**WELWYN HATFIELD BOROUGH COUNCIL  
EXECUTIVE DIRECTOR - PLANNING, PUBLIC PROTECTION AND GOVERNANCE**

**Application No:** 6/2018/2300/LB  
**Location:** Oshwal Centre Coopers Lane Road Northaw Potters Bar EN6 4DG  
**Proposal:** Omission of 5 x rooflights from south-facing roofslope of extension  
**Officer:** Mr William Myers

**Recommendation:** Granted

ROOF PLAN – WITHOUT ROOFLIGHTS (SCALE 1:50)

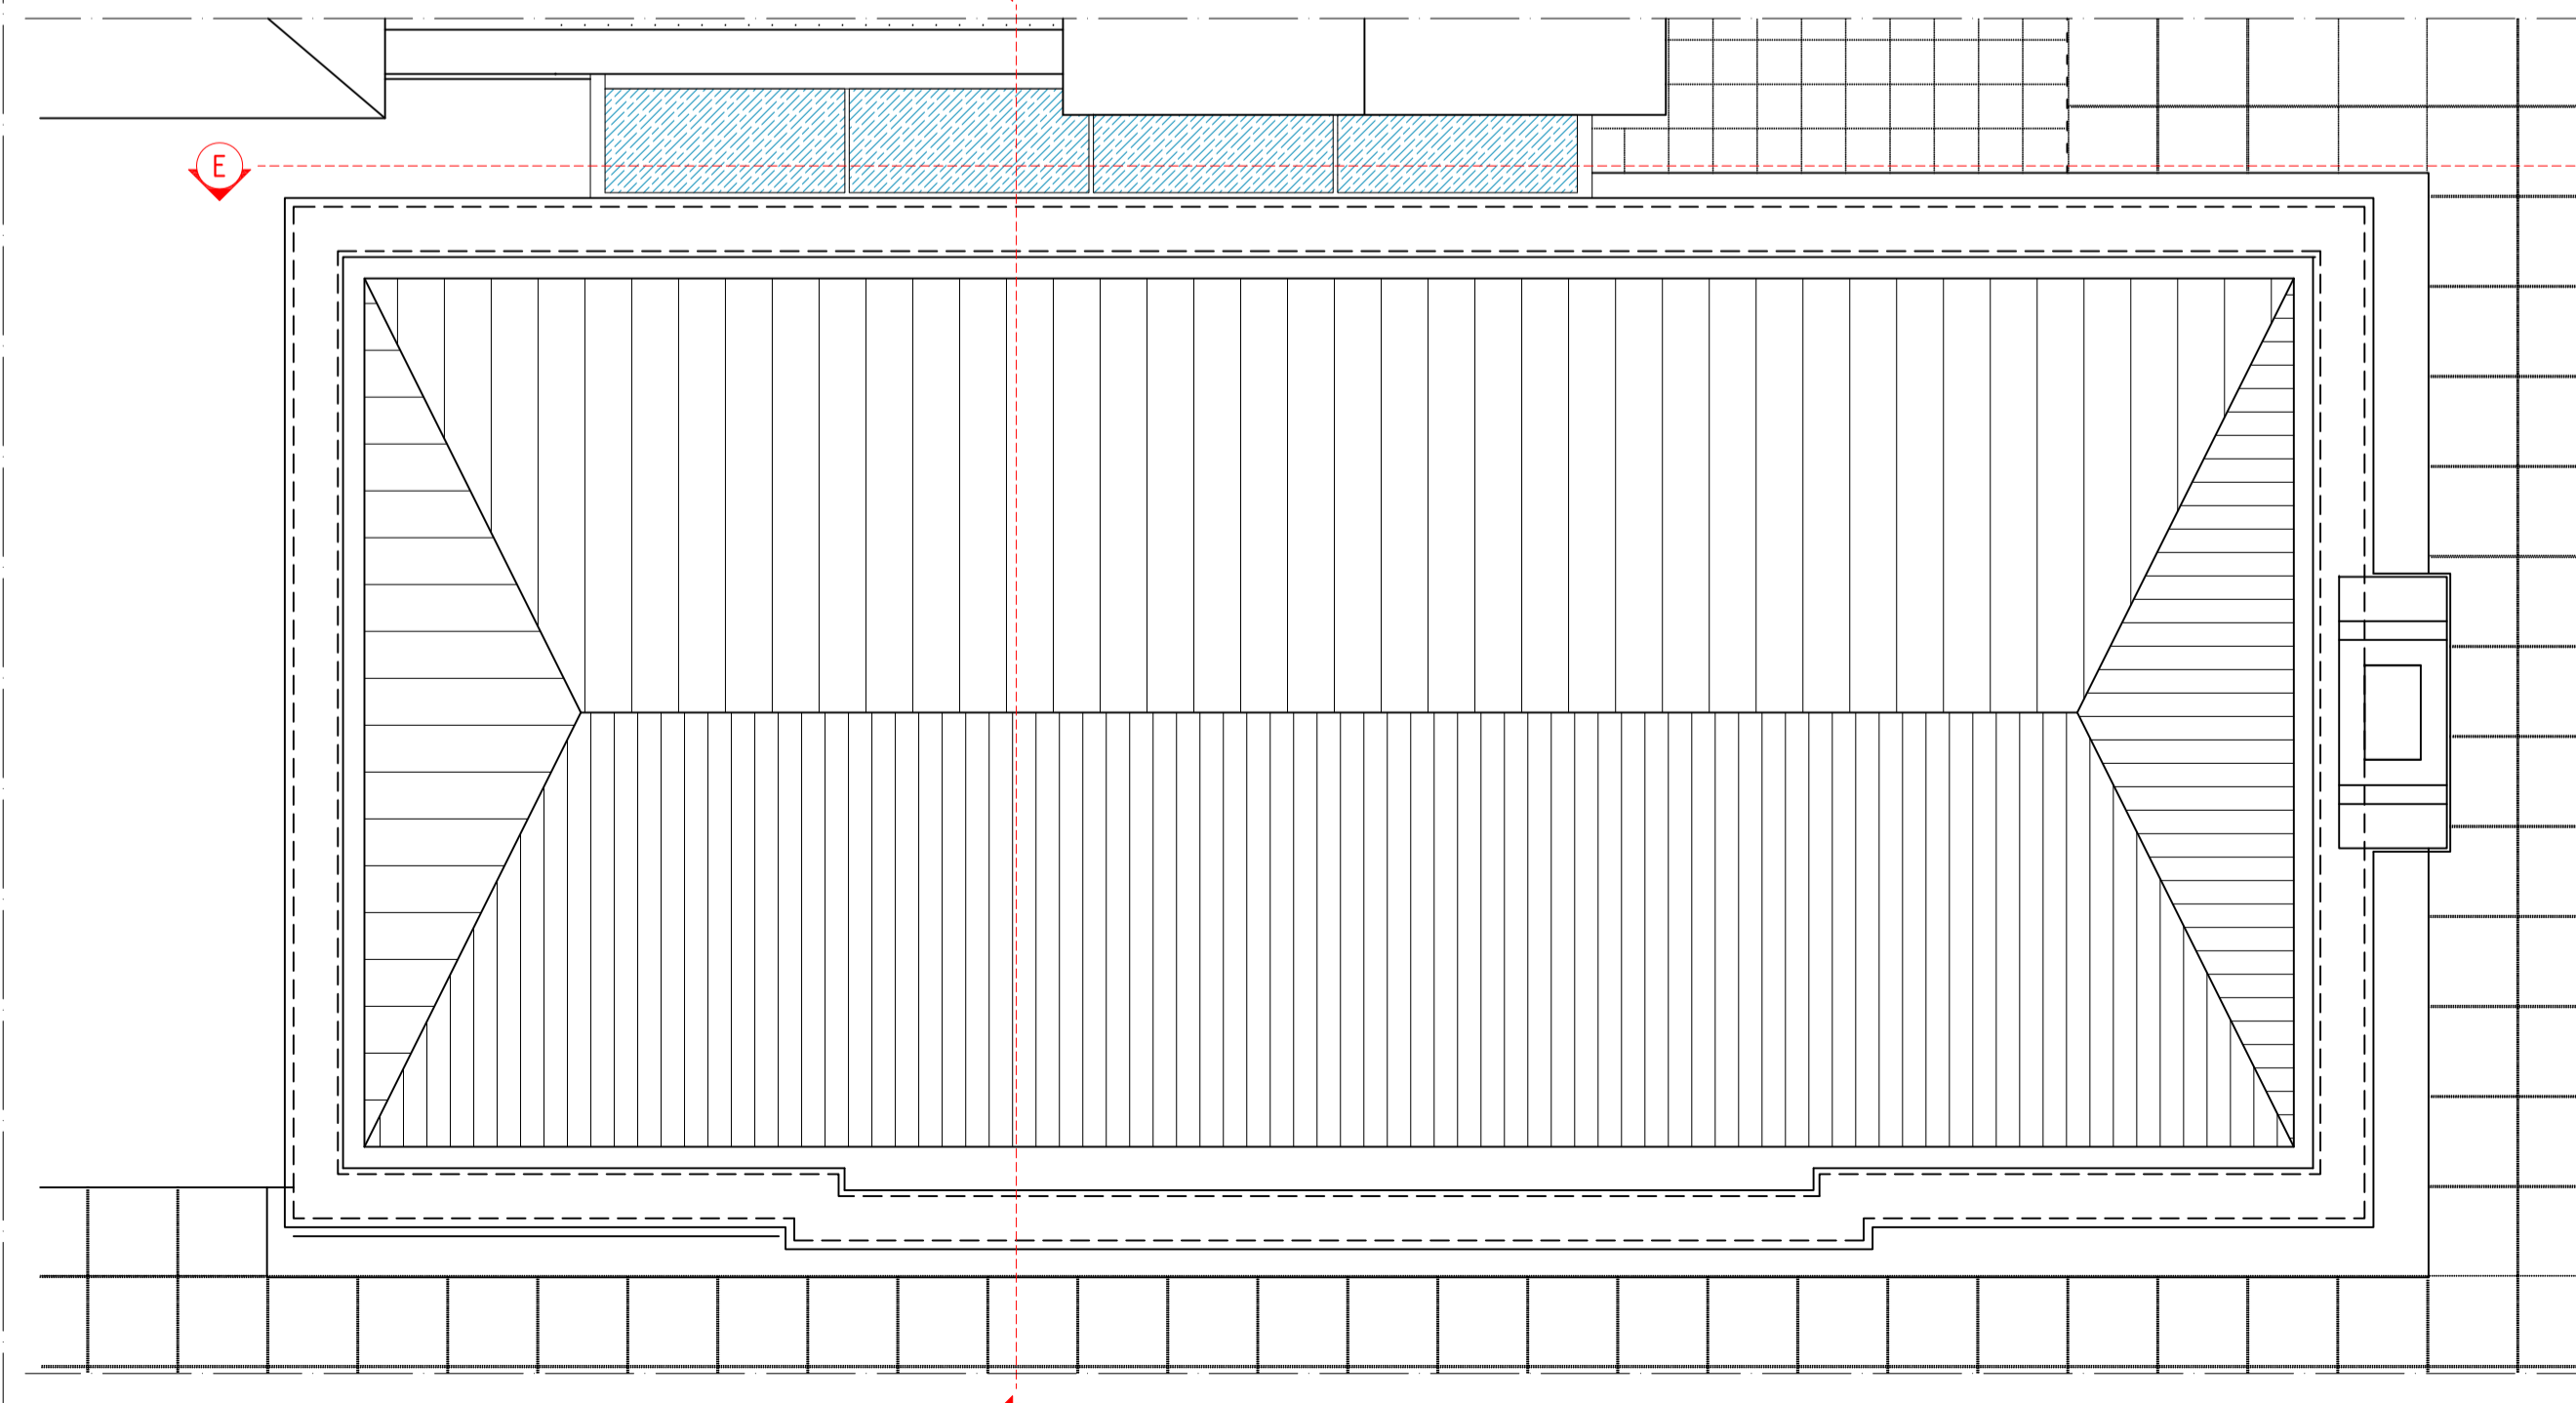
The omission of the rooflights on the south-facing roofslope (facing the rear of the house) of the new extension raises no objections. Their removal is considered to be an enhancement to the scheme as it simplifies the roof scape and the solid, uninterrupted roof is less of a visual distraction. It is therefore recommended that listed building consent is granted. No conditions are considered necessary.
<b>Any other considerations</b>	<i>Neighbour Objection</i>  It is noted that a neighbour has objected to the proposal on the basis of the activities that are occurring on the site and the amount of light that currently shines out from the site. As this application is for the removal of skylights, which were approved previously, it is not consider that the proposal would not result in an increase in the amount of light which would shine out of the site. In addition, as this application does not relate to the level of activities on site but simply the removal of skylights, it is not judged that the proposal would result in an increased level of activity within the site if the application were approved.
